FIVE ESTUARIES OFFSHORE WINDFARM

**Appendix O4 Natural England's comments on 10.20.2 Technical Note - Offshore
Decommissioning [REP2-028]**

Planning Inspectorate Reference EN010115

03 December 2024

**Figure 5 Maximum length of cable in SAC**

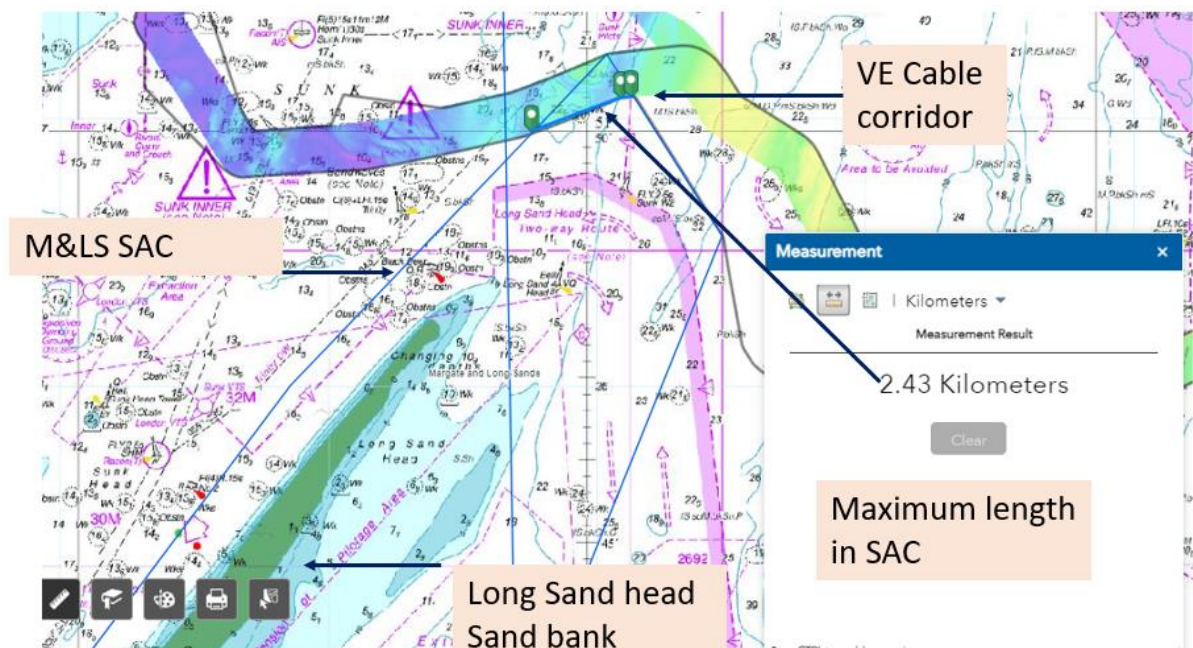
Natural England notes that the offshore decommissioning technical note does not consider the removal of scour/cable protection at the end of the project lifetime citing '*...the approach will be based on an assessment of relative net environmental benefit taking into consideration the in situ ecological value of offshore components alongside other factors...*', which indicates an intention to leave cable protection in situ, including within Margate and Long Sands Special Area of Conservation (MLS SAC). The leaving in situ of cable protection within MLS SAC is of particular concern to Natural England.

Natural England's current advice is that we do not agree with the Applicant's conclusion of no Adverse Effect on Integrity (AEoI) in relation to MLS SAC from lasting habitat loss/change resulting from the placement of cable protection over the lifetime of the project, even with an

expectation that it will be removed at the time of decommissioning. This advice is consistent with the advice provided on all offshore windfarms since Hornsea Project Three, where cable protection within Annex I sandbanks has been proposed. The Secretary of State (SoS) decision for Hornsea Project Three, Norfolk Boreas, Norfolk Vanguard and Sheringham Shoal and Dudgeon Extensions Projects (DEP and SEP) supports this position; and has placed a requirement on those projects to provide compensation measures.

Natural England therefore advises that without a commitment to remove cable protection at the time of decommissioning, impacts can no longer be considered to be 'lasting' for the duration of the project and will be a permanent impact within MLS SAC.

Therefore, while we agree that the present HRA/EIA may not be sufficient to fully determine decommissioning impacts at the end of the OWF lifespan every effort should be made at the consenting phase to ensure that decommissioning impacts can and will be minimised as much as possible through project design commitments (e.g., only using appropriate cable protection that is readily removable).
